**From:** Elliott, Stanice  
**Sent:** Monday, December 19, 2016 3:01 PM  
**To:** 'David Soule'  
**Subject:** Sunset Gardens Subdivision

Based upon the information provided in your submittal received 12-16-2016, the above referenced plan cannot be approved for PAD CERT until the following comments are addressed:

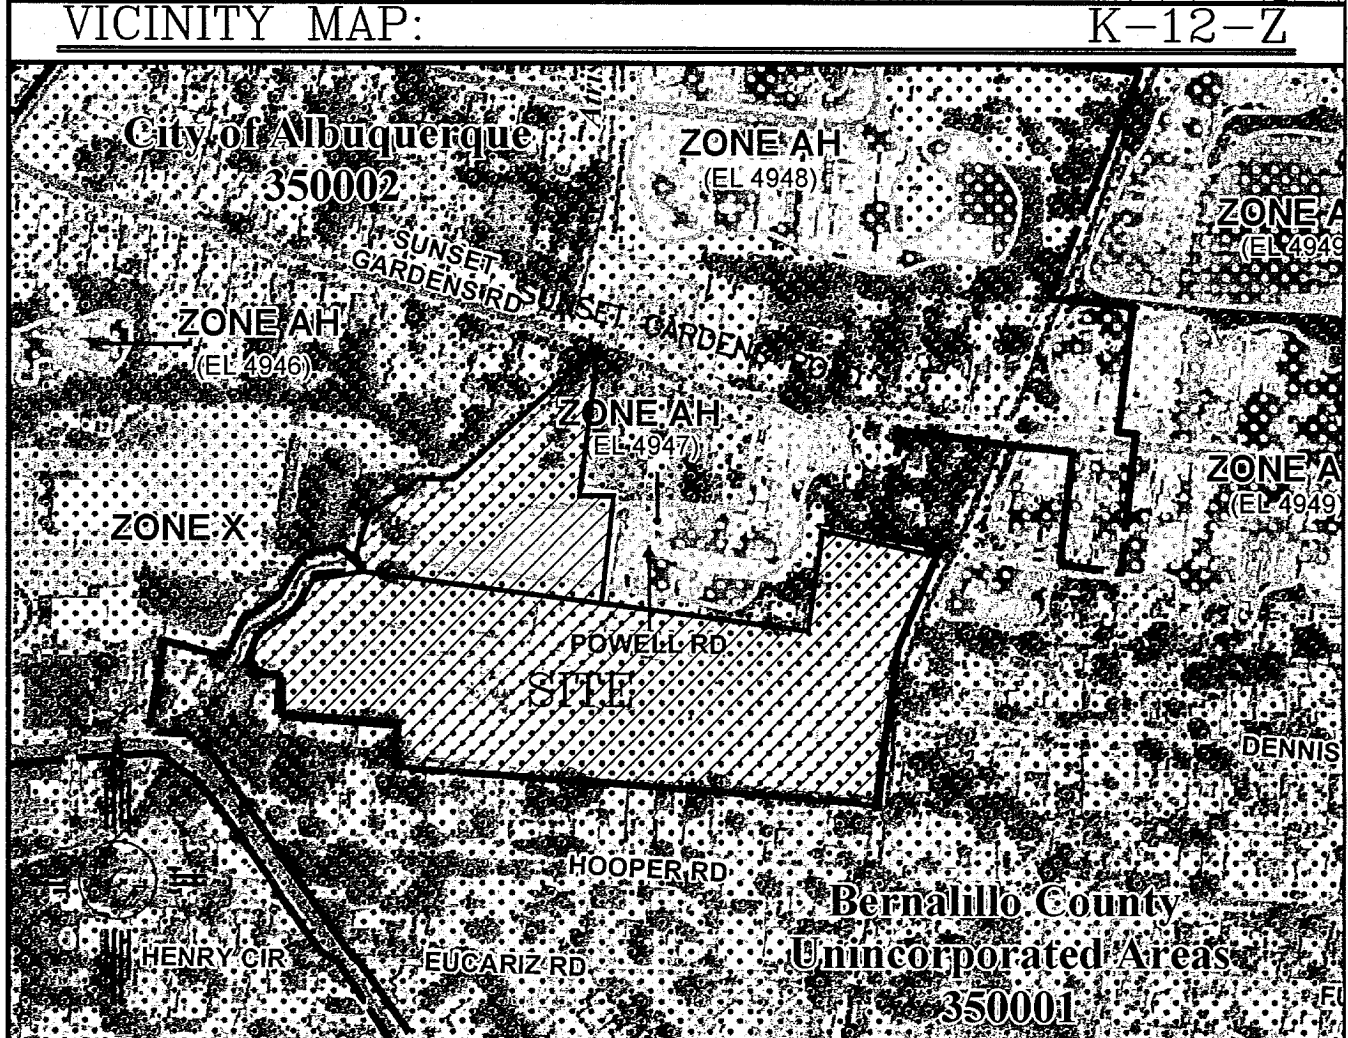
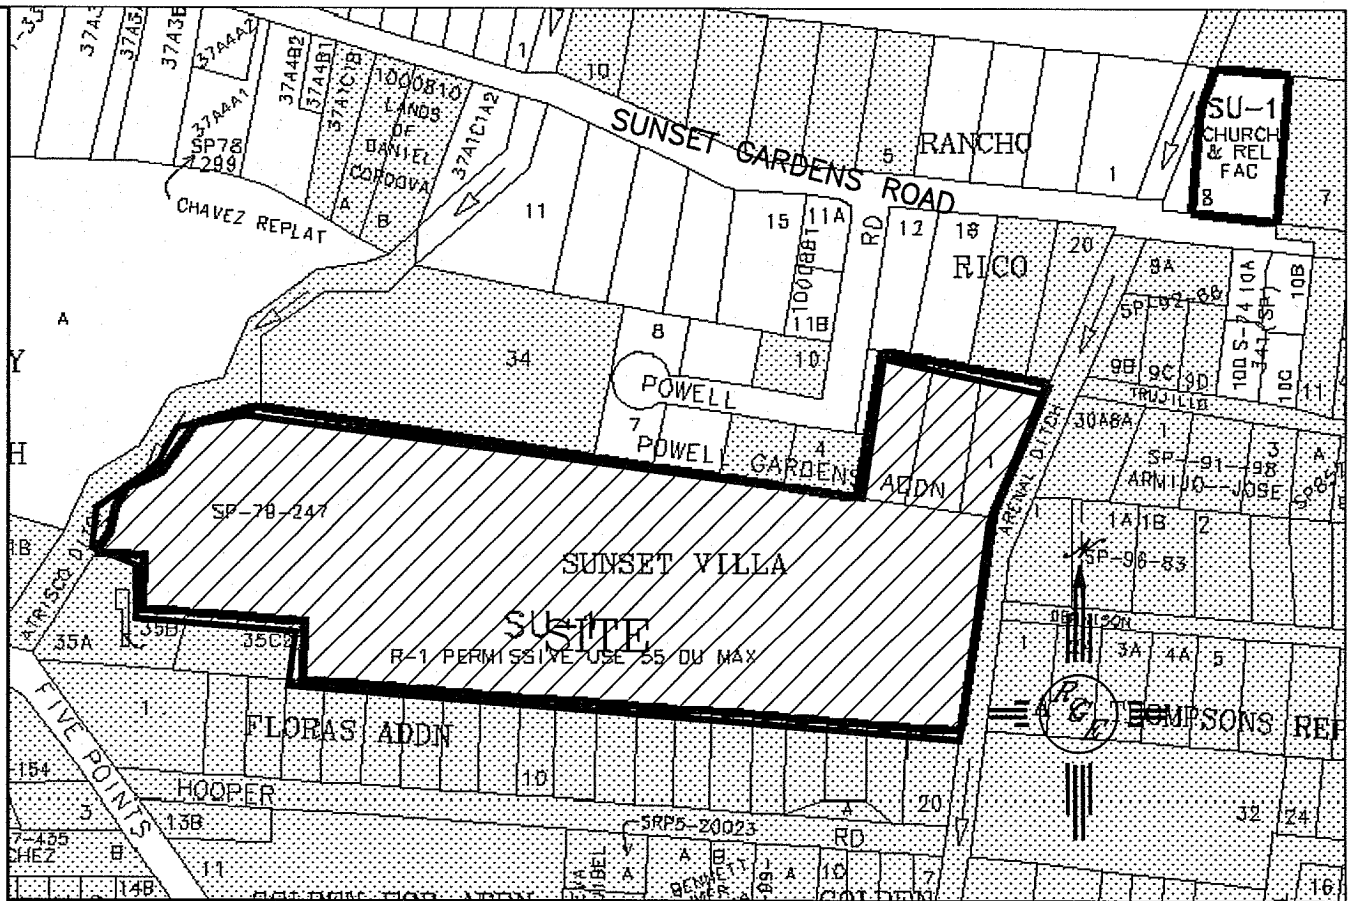
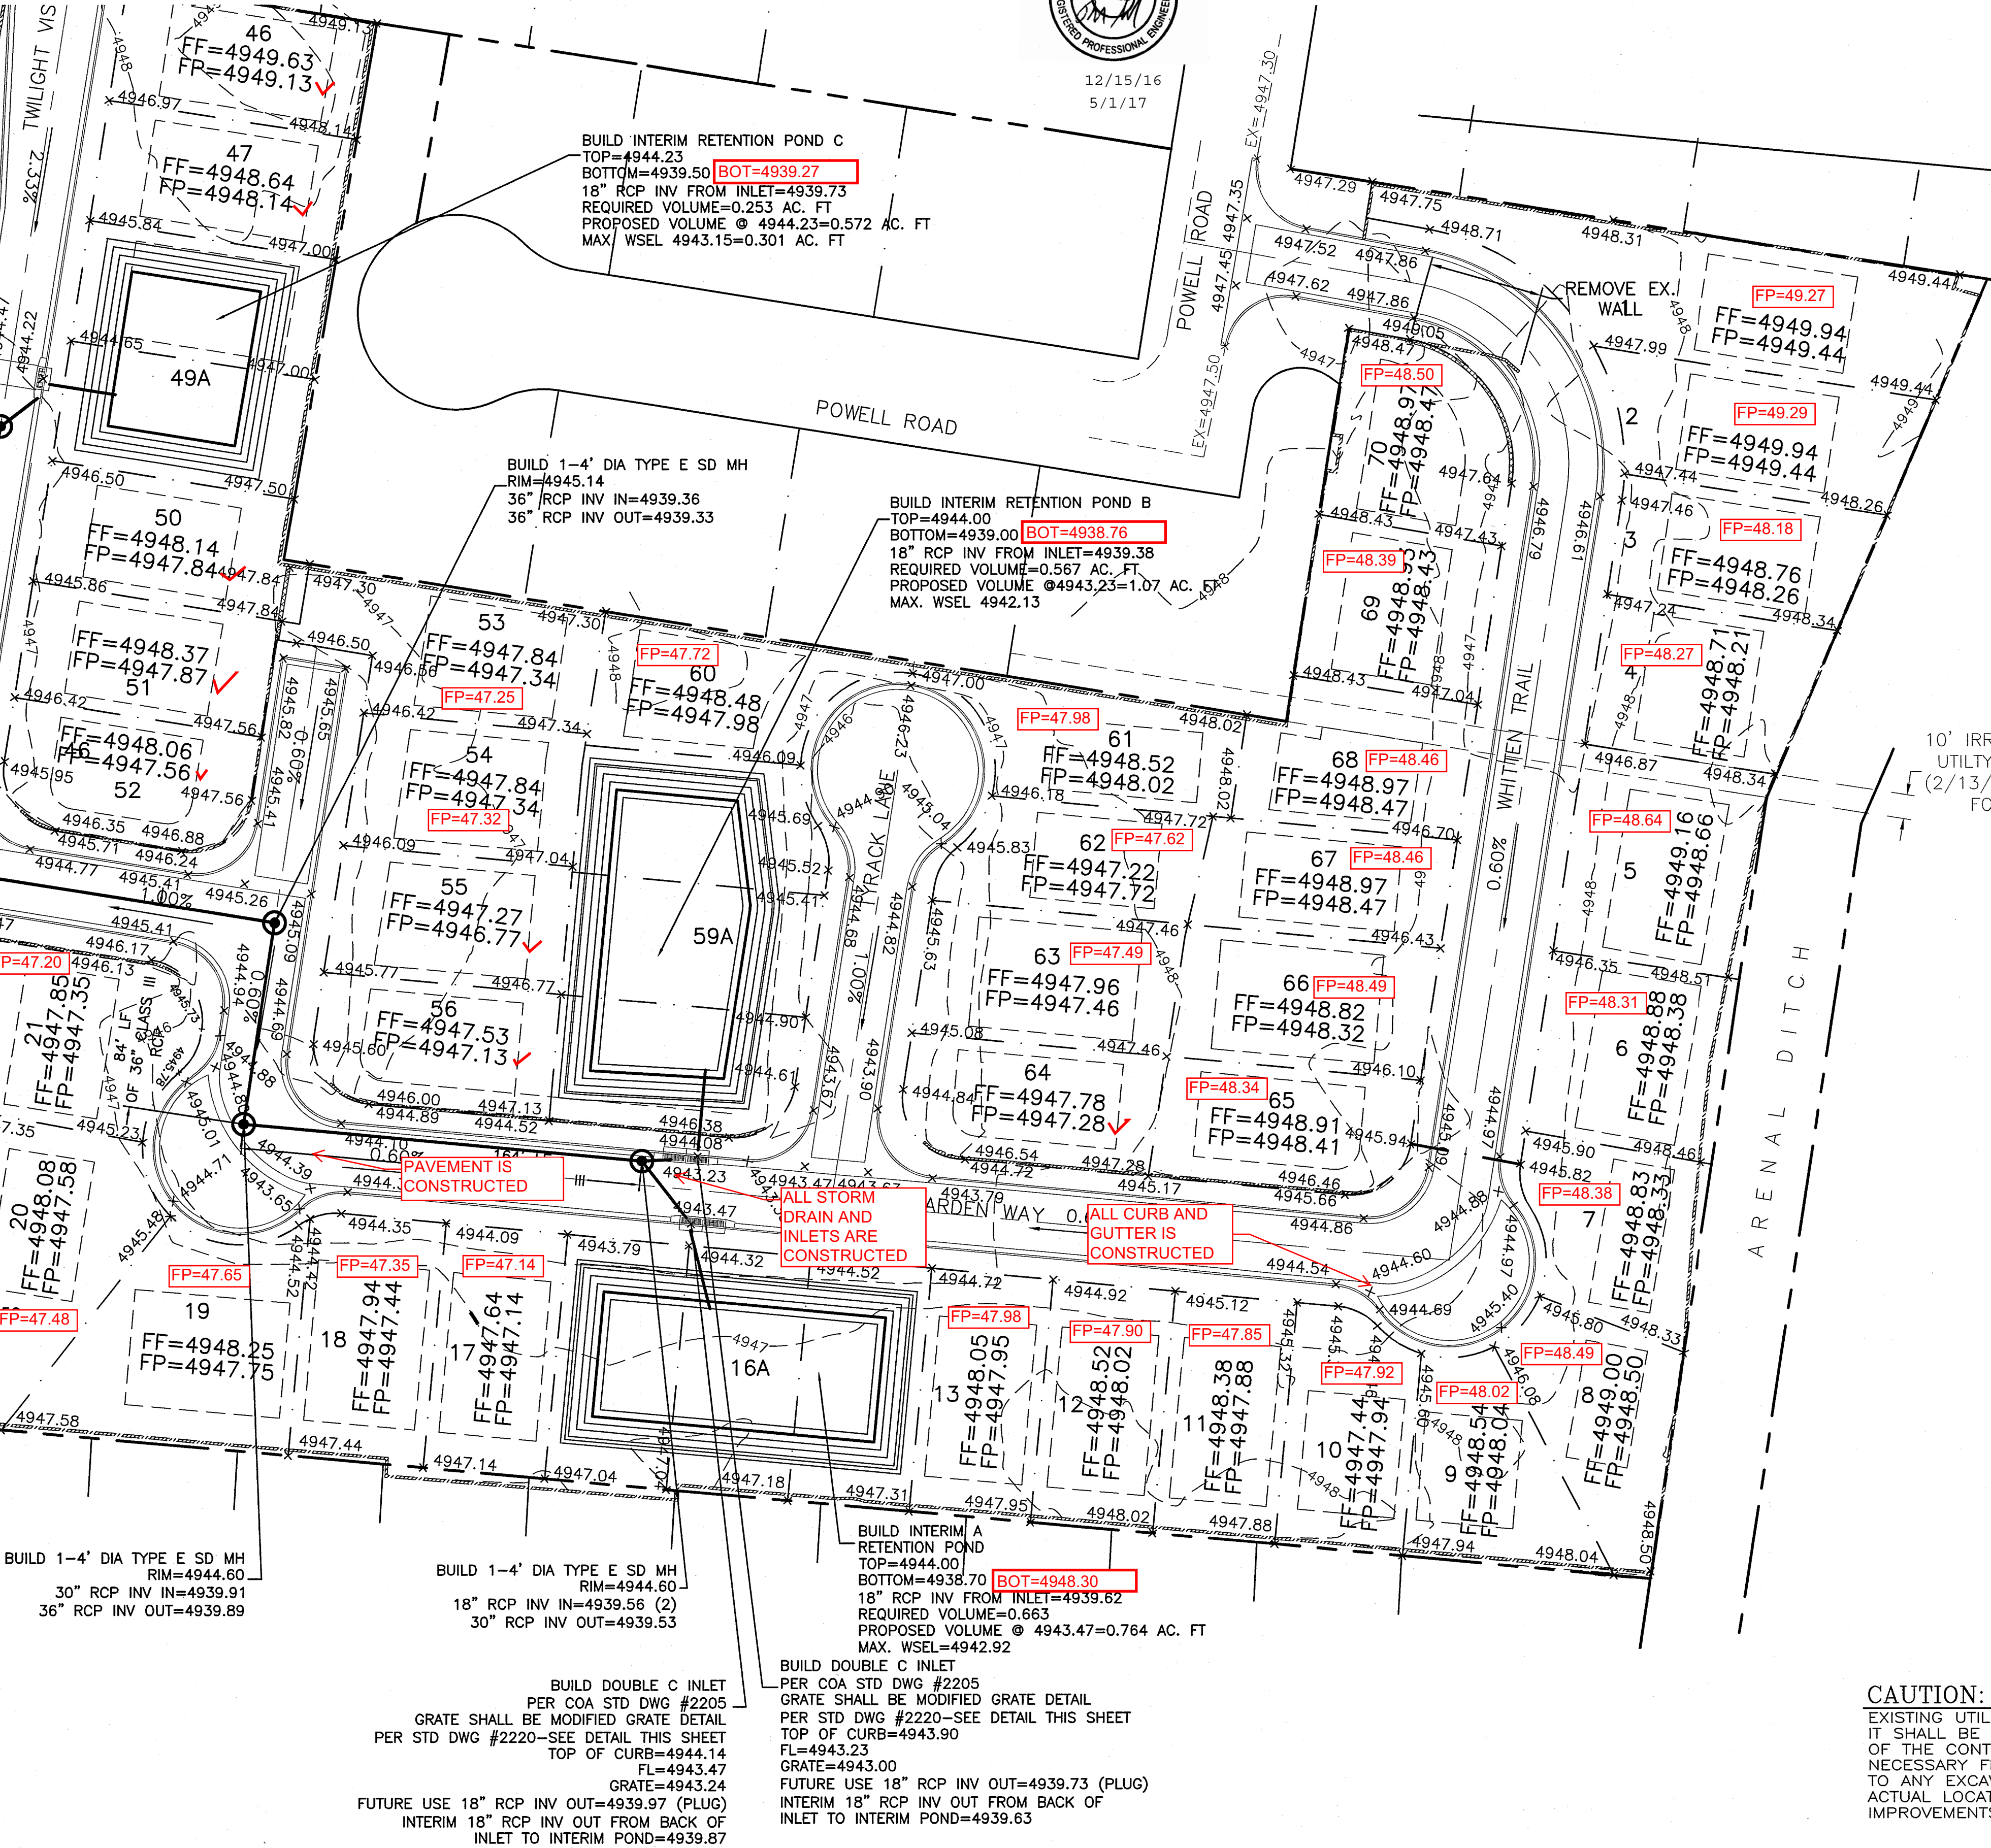
- No site access.
